Final Drainage Report – Filing No. 1

Waterview East Commercial El Paso County, Colorado

Prepared: July 16, 2026

EDARP File No.: SF269

APPENDIX F – DRAINAGE EXHIBITS

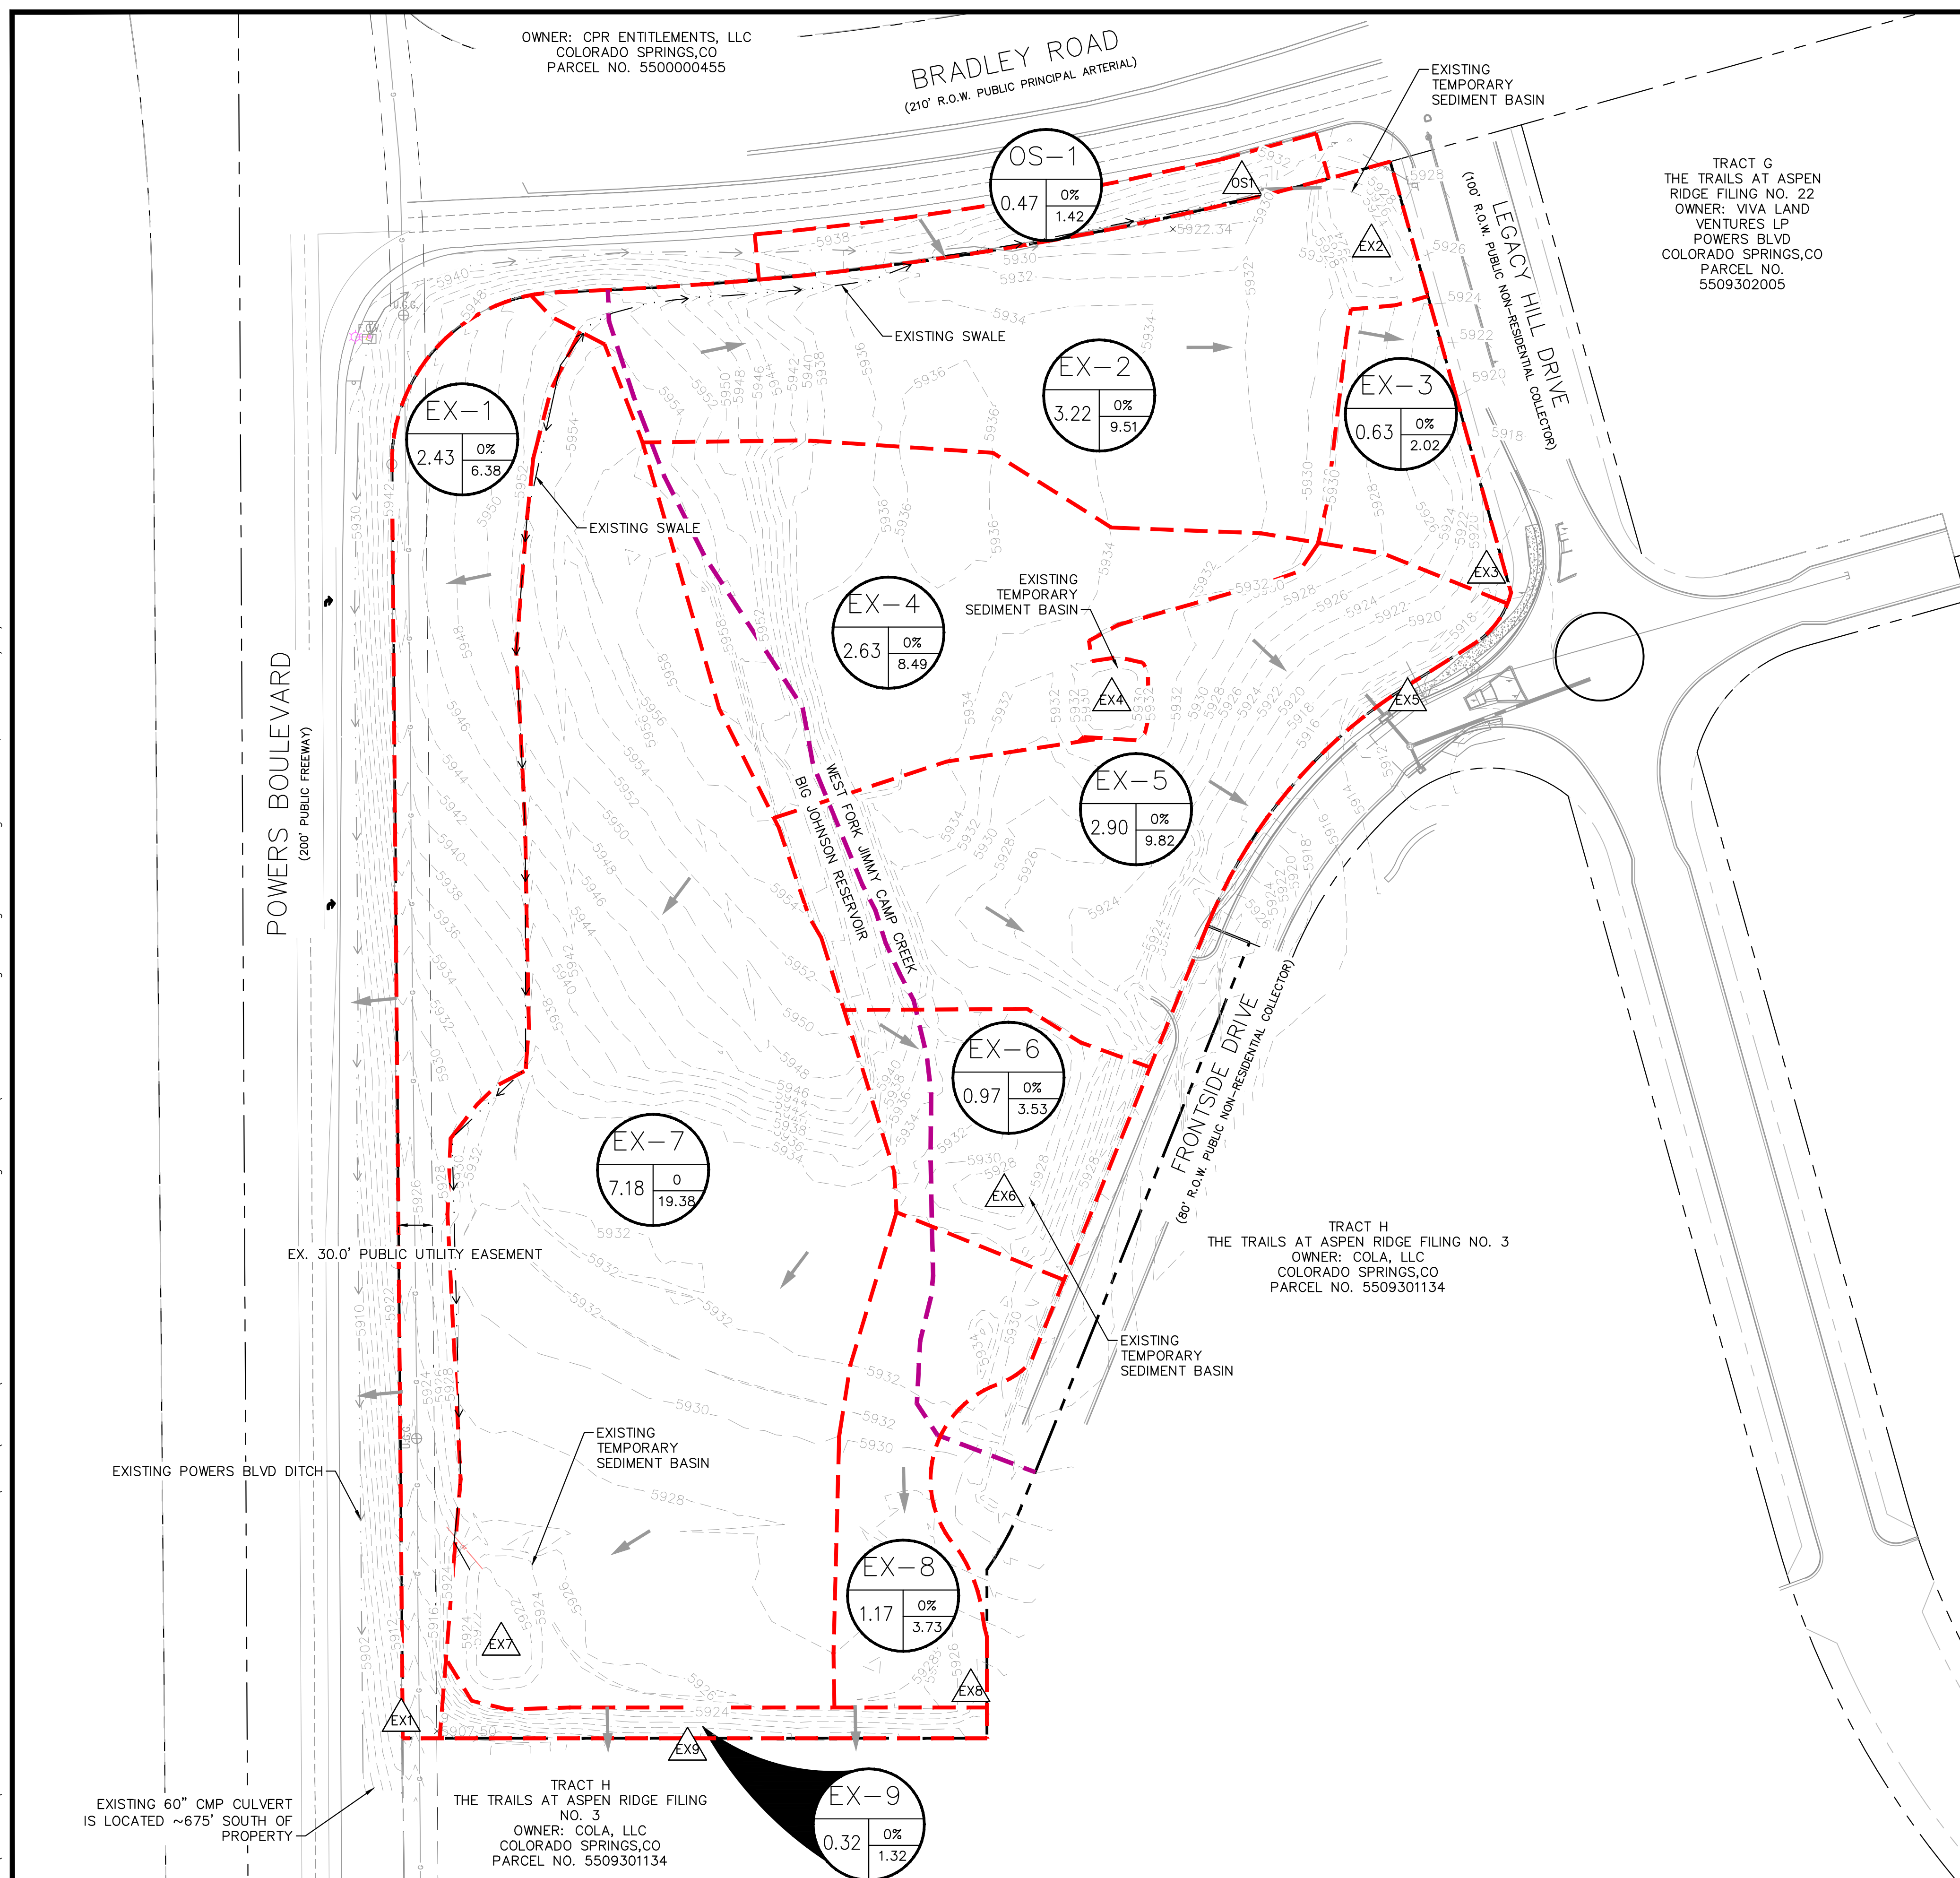
Label inlet on map

KH Response:
Label added
